KIRKLEES METROPOLITAN COUNCIL INVESTMENT & REGENERATION SERVICE

DELEGATED DECISION TO DETERMINE PLANNING APPLICATIONS

Reference No:	2024/62/91758/W
Site Address:	14, Laithe Bank Drive, Holmbridge, Holmfirth, HD9 2PL
Description:	Erection of two storey and single storey side extensions and alterations.
Recommending Officer:	Lucy Taylor

Officer Report.

NORTH EAST ELEVATION - 1:100
LAI THE BANK DRIVE
PROPOSED

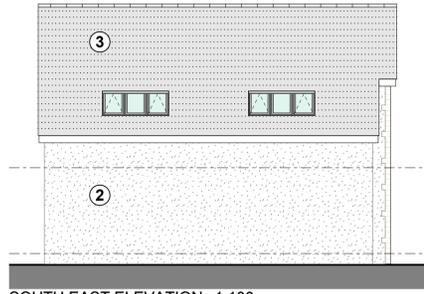
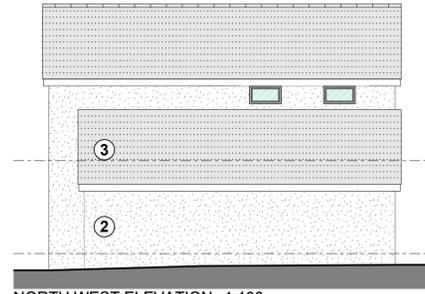
The proposed two-storey side extension and single storey side extension to 14 Laithe Bank Drive are considered to be subservient additions to the host property, set down from the host ridge height and set back from the host principal elevation. In addition, the extensions retain a minimum distance of approximately 2 metres from the nearest boundary of the site, in turn, retaining an appropriate sense of openness.

Given the setback position of the proposed extensions from the principal elevation of No. 14, they will be read as being set back from the established building line along Laithe Bank Avenue. Whilst the proposed two-storey side extension to the south eastern side elevation of No. 14, will exceed the building line of No. 7 Bankfield Drive to the rear, given the separation distance retained from the sitting of No. 7 and, in turn, the retained sense of openness, based on the individual merits of the application site and proposal, in this instance, such a design is considered to be justifiable.

Whilst only velux windows are proposed in the side elevation of the extension, facing out towards Laithe Avenue, this is considered to be sufficient in providing the effect of a frontage to this elevation, adding some degree of glazing. It is noted that, corner plot property No. 10 Bankfield Drive, located to the west, does not have any glazing to its elevation facing out towards Laithe Avenue.

3. The external walls of the extensions hereby approved shall be faced in natural stone and render to match the host property and the roofs of the extensions shall be infilled with matching concrete interlocking pantiles. These materials shall thereafter be retained.

BLOCK PLAN - 1:500
PROPOSED

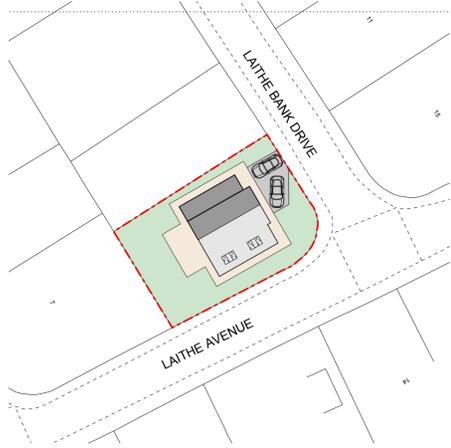
The proposal seeks to increase the number of bedrooms from three to four. Key Design Principle 15 of the House Extensions and Alterations SPD sets out that 4+ bedroom dwellings should provide 3 off street parking spaces.

The submitted block plan shows that 2 off-street parking spaces will be retained to the front of the property. Whilst officers note that this is one space below the recommended standards within the House Extensions and Alterations SPD, on balance, it is considered that the level of parking provided is adequate, with on-street parking available around the site, on the highways of Laithe Bank Drive and Laithe Avenue.

Upon any grant of approval, a condition shall be imposed regarding the surfacing of any additional areas of hard standing and that they are used for parking.

4. The extensions hereby approved shall not be brought into use until any areas of additional hard surfacing have been laid out with a hardened and drained surface in accordance with the Communities and Local Government; and Environment Agency's 'Guidance on the permeable surfacing of front gardens (parking areas)' published 13th May 2009 (ISBN 9781409804864) as amended or any successor guidance; Notwithstanding the provisions of the Town and Country Planning (General Permitted Development) (England) Order 2015 as amended (or any Order revoking or re-enacting that Order) this shall be so retained, free of obstructions and available for parking.

GROUND FLOOR PLAN - 1:50
PROPOSED

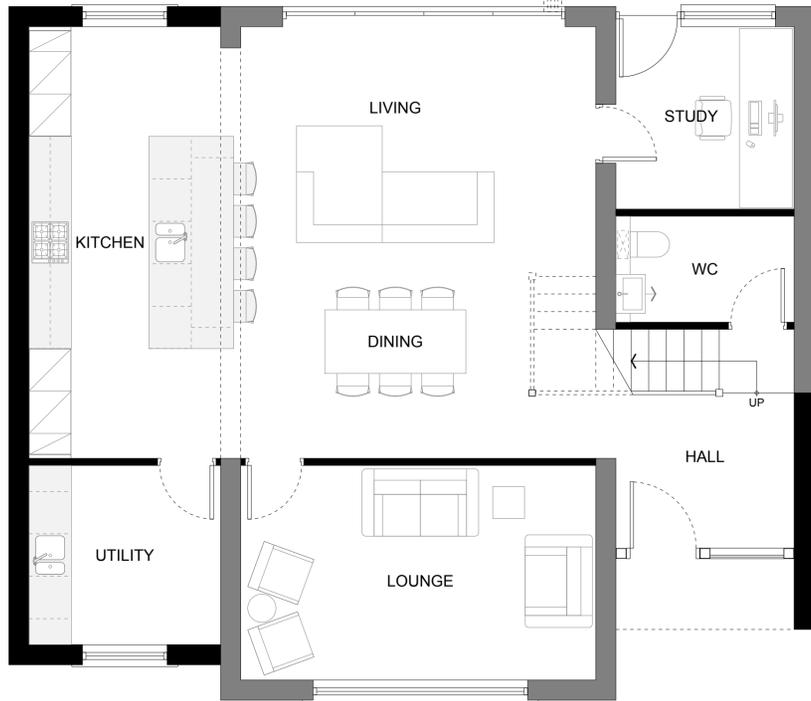
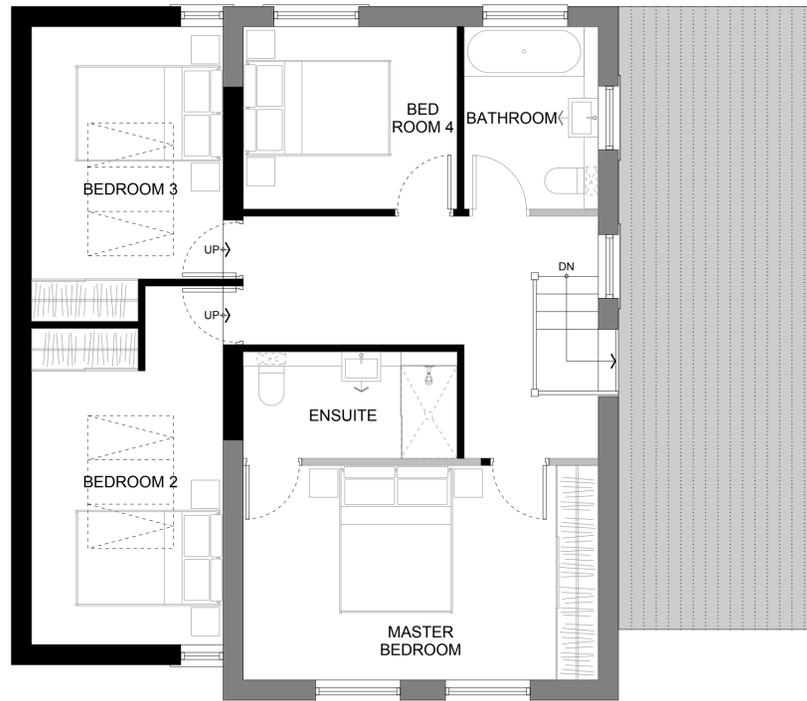
The proposed extension to the side elevation of No. 14 adjacent to No. 12 is to be single storey in height and is to retain a minimum separation distance of approximately 2 metres from the shared boundary.

Furthermore, the development does not include an increase in habitable room glazing to face towards No. 12 Laithe Bank Drive. Therefore, it is not considered that the proposed development would result in undue impacts of overlooking towards No.14.

The development proposes the addition of habitable room glazing to both the ground and first floor of the rear elevation of No. 14. Given the separation distance to be retained between the proposed glazing and the shared boundary with No. 7 Bankfield Drive, as well as the bungalow height of No. 7, it is not considered that the additional glazing to the rear elevation would result in undue impacts of overlooking.
